Reference: 0468089

**Subject: Grocon Group Ribbon Development Response**

ERM has been engaged by Grocon to provide a brief letter detailing a review of the proposed monitoring system and a response to the Road and Maritime Services (RMS) information request (dated 13 March 2019 - document reference SYD15/01513/13) and the Department of Planning & Environment (DPE) information request (Dated 15 March 2019 – document reference SSD 7388 MOD 7).

**2** HOTEL/SERVICED APARTMENTS L22  
1:200

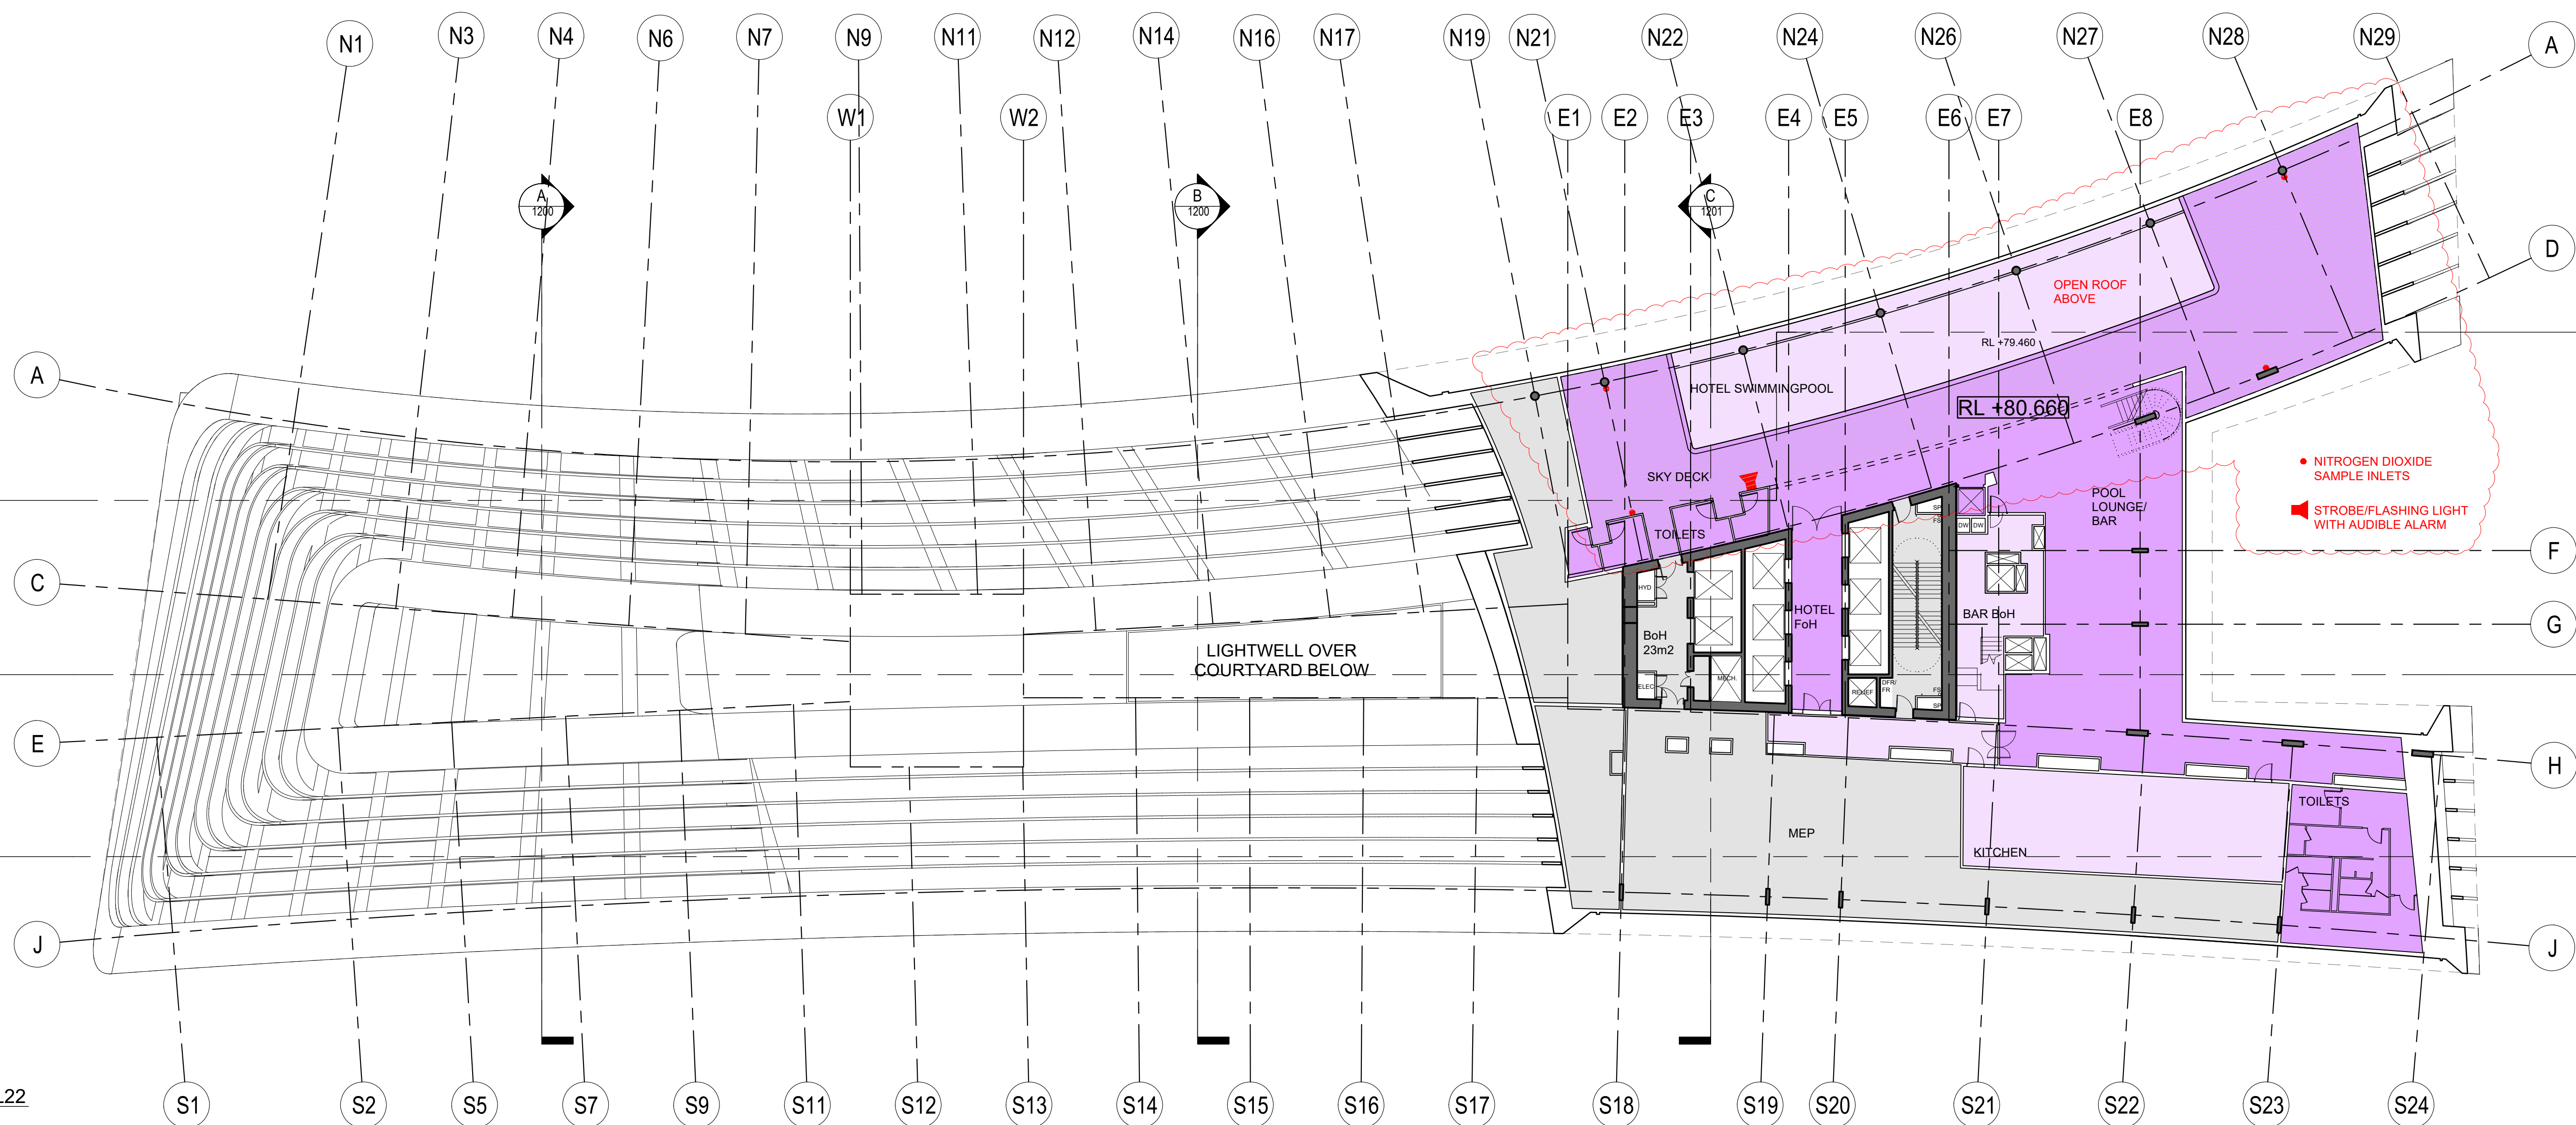
**Figure 3.2** shows four sample inlets spaced around the pool deck area. Following discussions with the equipment provider, Lear Siegler, it is anticipated that all sample inlets will draw air to a central sampling manifold within the plant room (refer **Figure 3.1**).

It is considered that drawing air from these sample inlet locations will result in a composite air sample that is representative of the potential exposure to nitrogen dioxide experienced by occupants of the pool deck area.

**DPE Item:** *Plans - Clarify the rationale for the proposed number and location of NO<sub>2</sub> sensors. If the sensors are to be located externally, provide appropriately scaled drawings (including elevations) clearly illustrating the proposed sensors, mounting brackets and any weatherproofing or other housing proposed. Consideration should be given to minimising the impact to the external appearance of the building.*

Please see Section 3 of this document for the proposed locations of the NO<sub>2</sub> sample inlets (NB: not sensors). The sample inlets will be located on the underside of the open roofing on Level 23.

**1** HOTEL/SERVICED APARTMENTS L23  
1:200

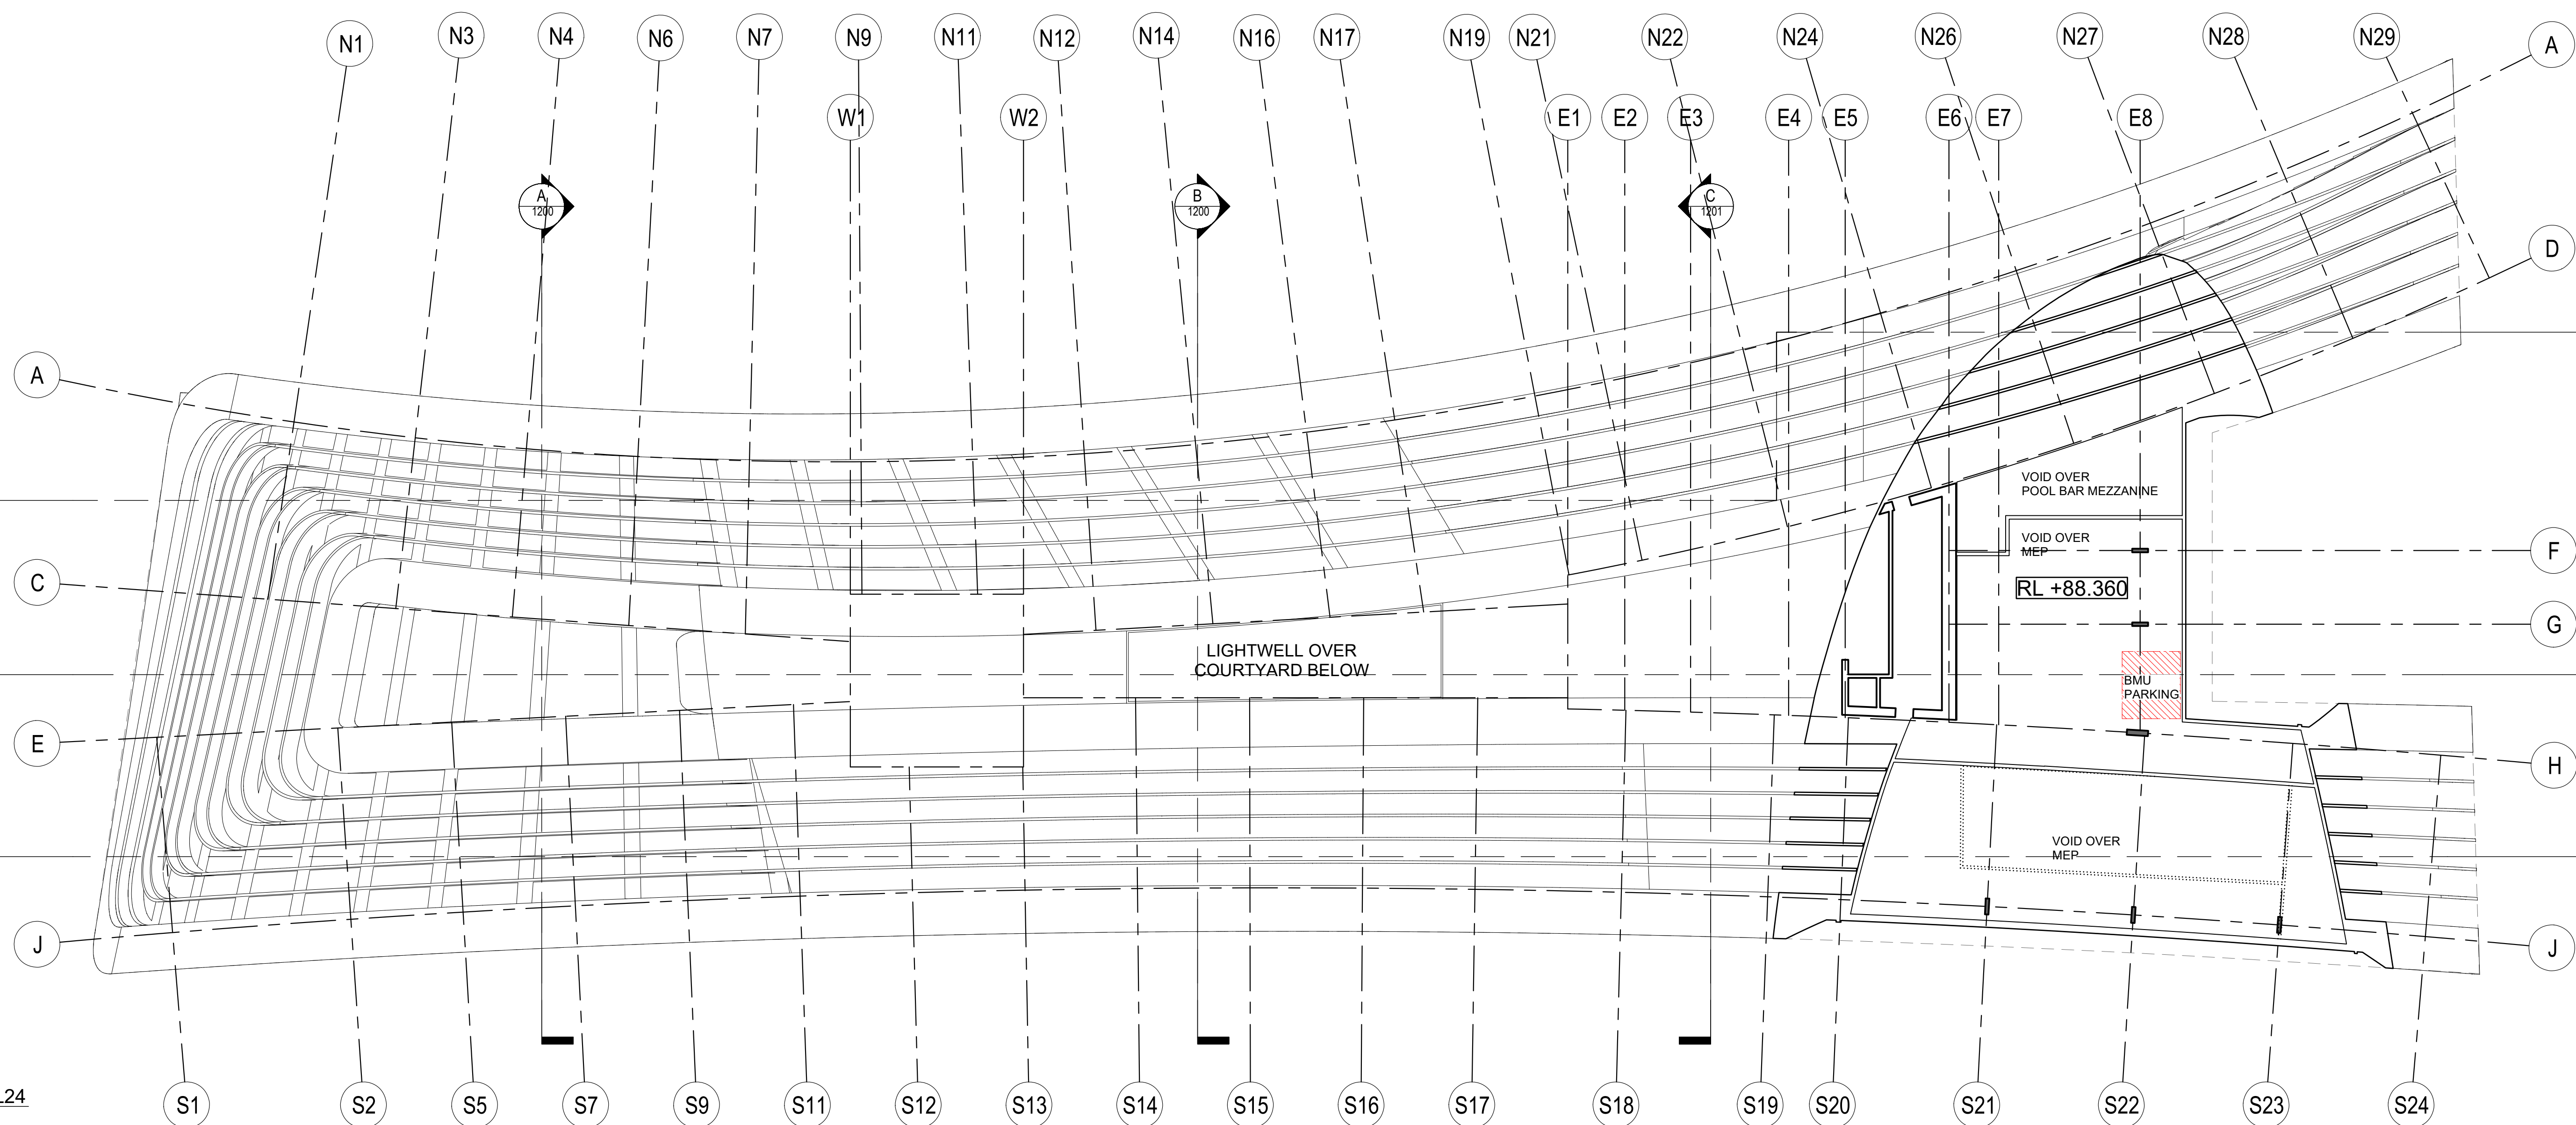
The proposed location of the NO<sub>2</sub> analyser equipment on Level 23 and the NO<sub>2</sub> sensor tube locations on Level 22 are presented in **Figure 3.1** and **Figure 3.2**.

Please note that these figures should read nitrogen dioxide analyser and nitrogen dioxide sample inlets as opposed to 'sensor tubes'.
